**App no: 23.0634**

**Address: Primrose House Primrose Road Clitheroe**

**Proposal: Planning permission for proposed single-storey self-build dwelling with associated car port, parking and manoeuvring space, refuse storage, garden area, hard and soft landscaping, to be accessed via the Old Cotton Mill access following removal of a section of boundary wall**

Further to our original comments dated 11<sup>th</sup> September 2023, amended plans have been received and have been reviewed and the following comments are made.

Nova, Primrose Road, Clitheroe, BB7 1BS

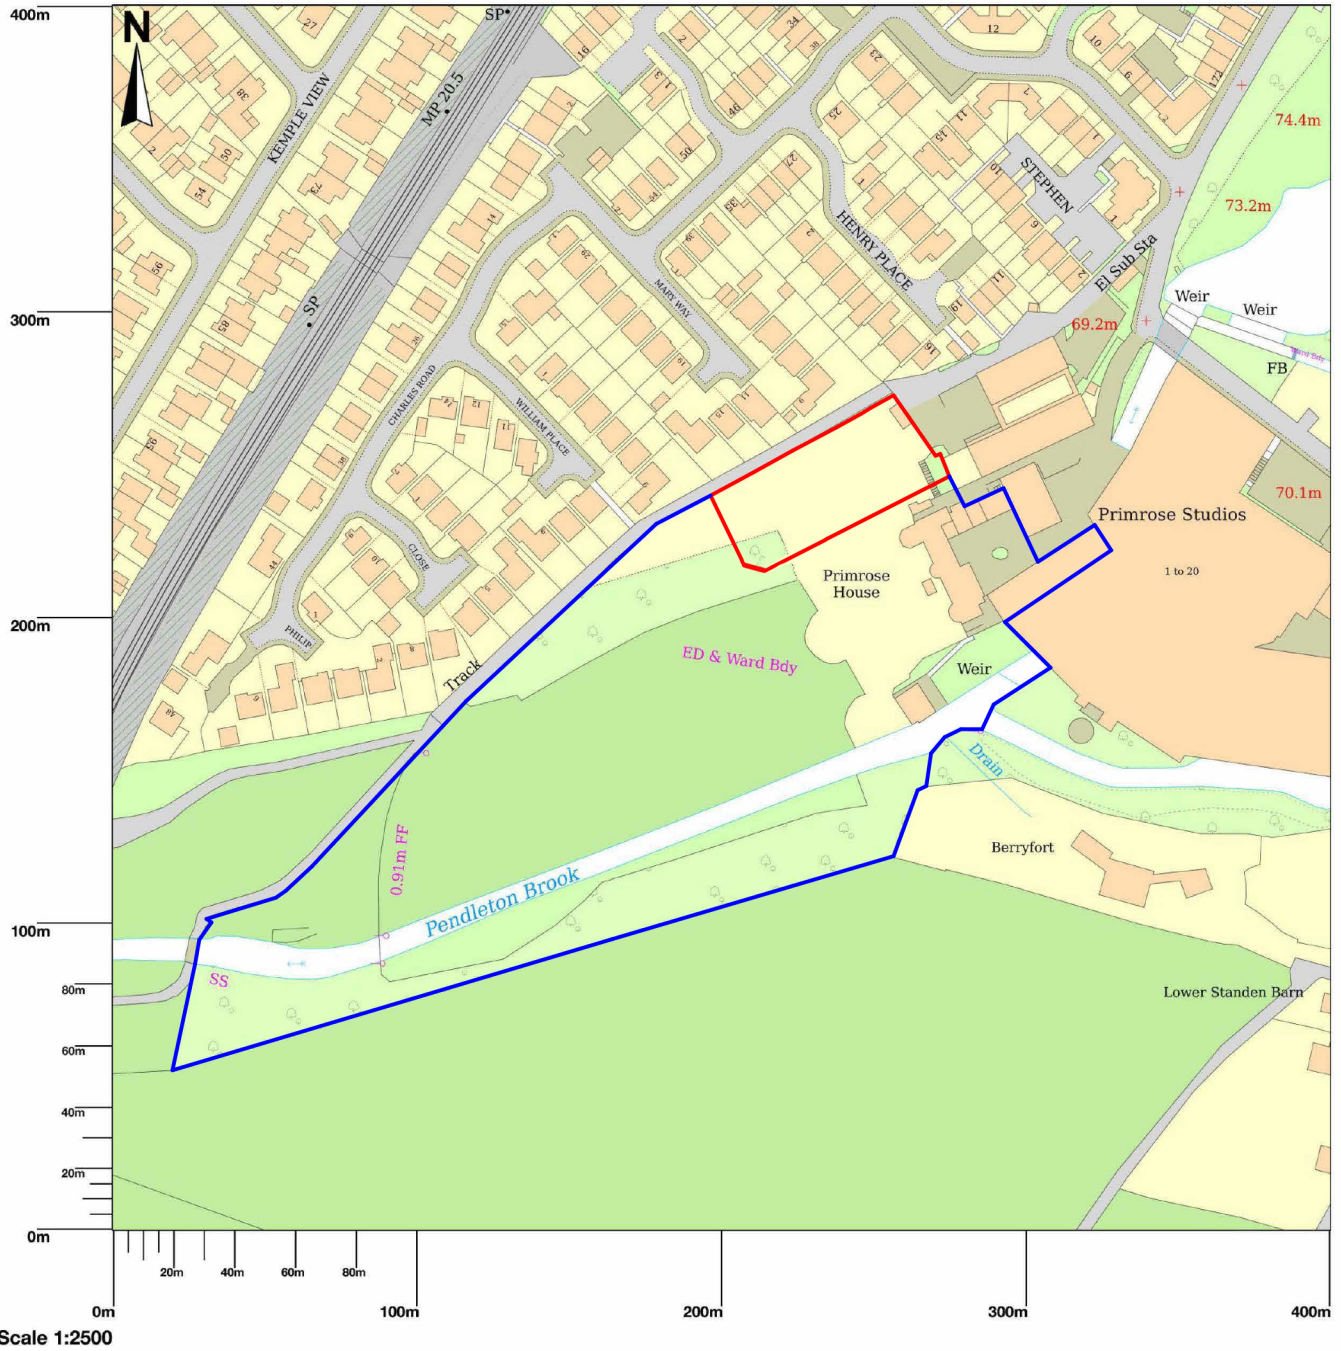
The Old Cotton Mil car park and private road are not within the red or blue edges on the location plan. The amended plans show the access road hatched blue and noted as 'right of way' and the applicant states in writing that they have a right of access to access along the private road to access the site.
